Subject: FW: 5 Terminus Road, Littlehampton (former Locomotive site)

The details submitted in landscaping plan dwg 3490-PC01 do not give the plant quantities, confirmation of which is required for clarity.

I would not recommend discharge of condition 4 on application LU/11/19/DOC until the plant quantities and the planting density for the planting areas are confirmed.

scale 1:100 drg no. 3490-PC02

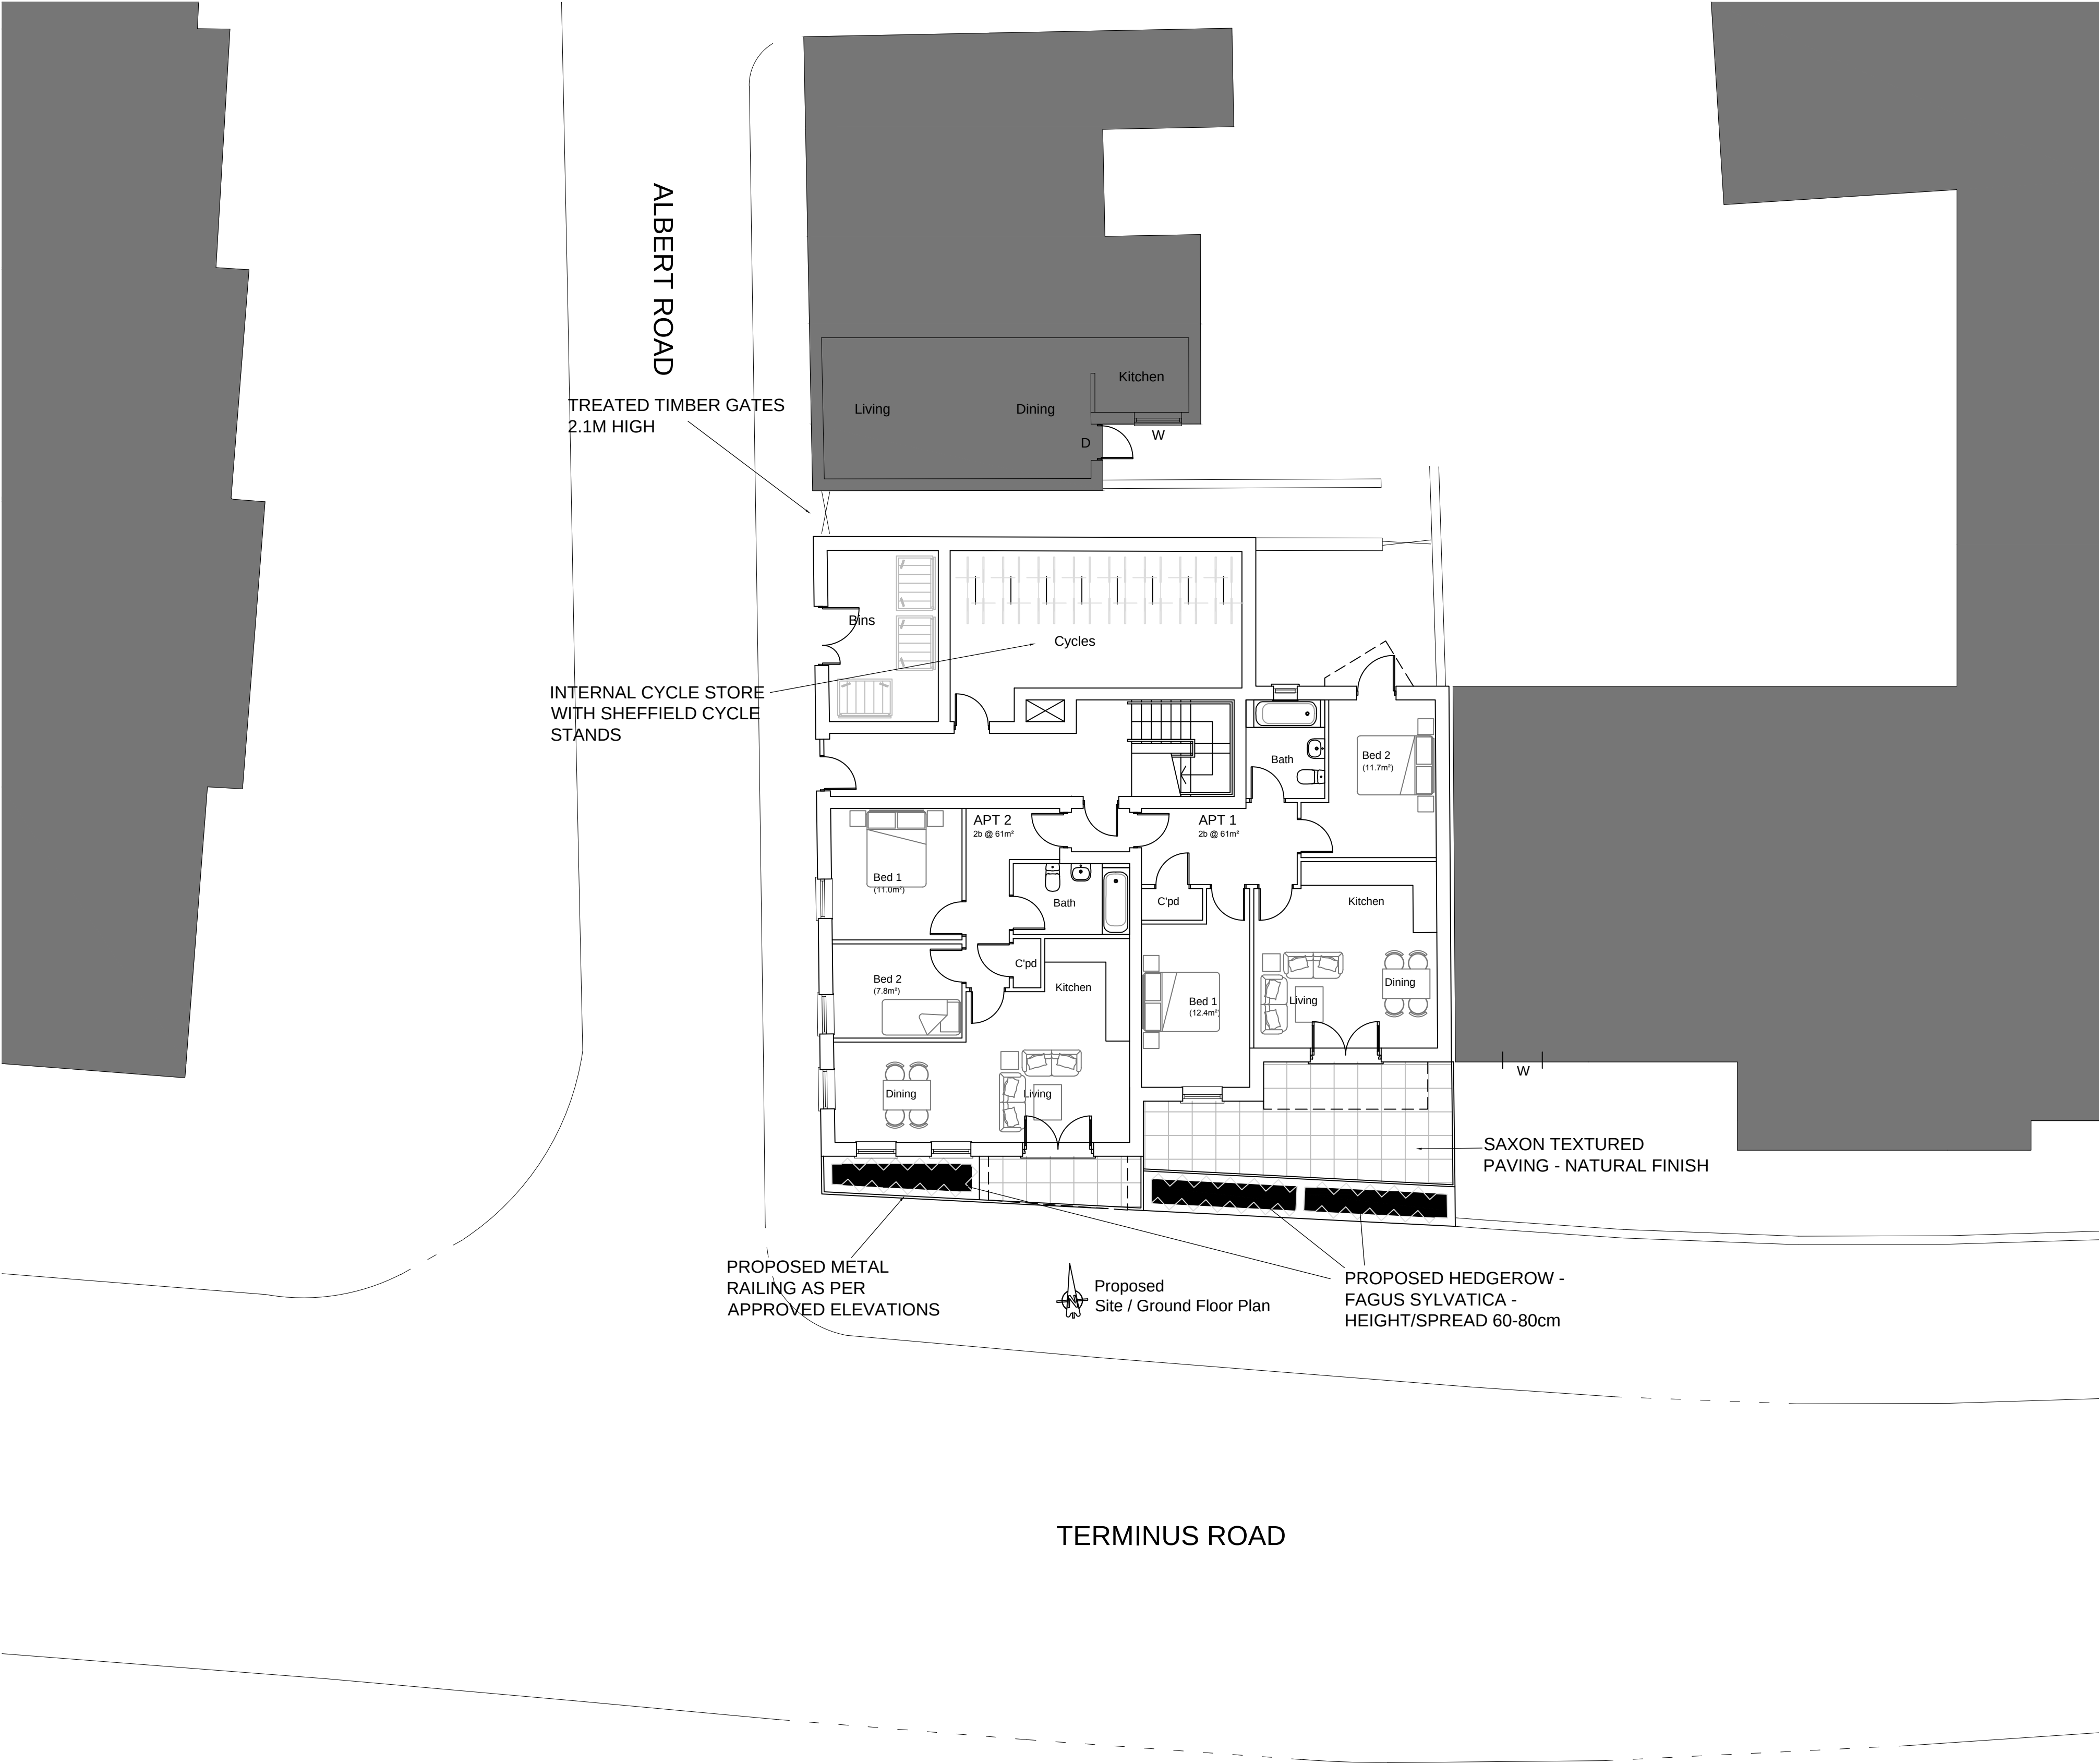
Please see comment from Greenspace below and please confirm plant quantities and the planting density for the planting areas .
